City of Portland
Development Review Application
Planning Division Transmittal Form

Application Number: 2014-027 Application Date: 03/21/2014
CBL: 444 A003001 Application Type: Level II Site Plan
Applicant: Shucks Maine Lobster LLC /Johnny
Project Name: Shucks Maine Lobster
Address: 6-44 COMMERCIAL ST
Project Description: Lobster processing facility to occupy approximately 18,400 sq ft of vacant space in Maine in Maine State Pier Building. Project requires conditional use approval.
Zoning: EWPZ

To: FILE
From: Shukria Wiar
Subject: Application ID: 2014-027
Date: 4/18/2014

Comments Submitted by: Marge Schmuckal/Zoning on 4/18/2014

READY SEAFOOD 390 COMMERCIAL STREET PROPOSED LOBSTER TANK INSTALLATION SECTION A-A		TEC ASSOCIATES <small>INCORPORATED</small> 1000 W. 10TH AVENUE DENVER, CO 80202 TEL: 303.733.8800 FAX: 303.733.8801 WWW.TECASSOCIATES.COM
SCALE 1/4" = 1'-0" 11/22/13	DATE 11/22/13 JOB #

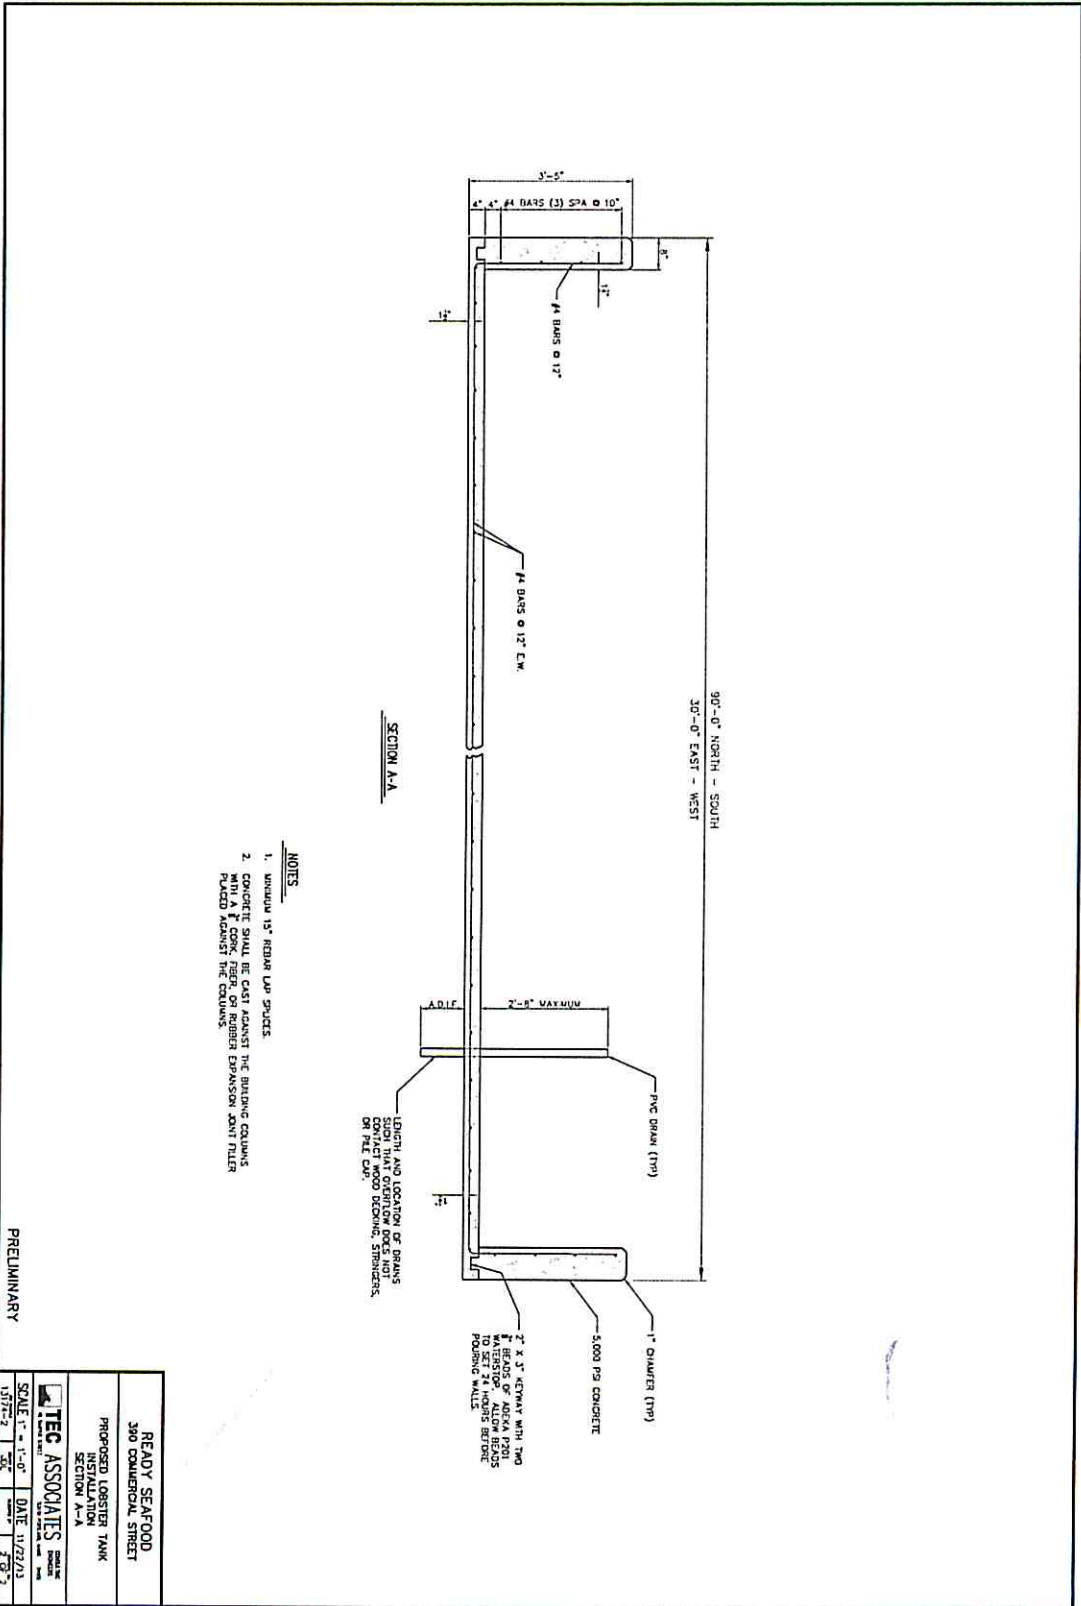
This project is allowed in the Eastern Waterfront Port Zone under a conditional use appeal to the Planning Board. The approximate 19,000 s f of area would require 9 parking spaces to be available under 14-332.1(j). They are showing more than the minimum number. The setbacks for the new entries are being met. I did not see the height of the new tank being installed.
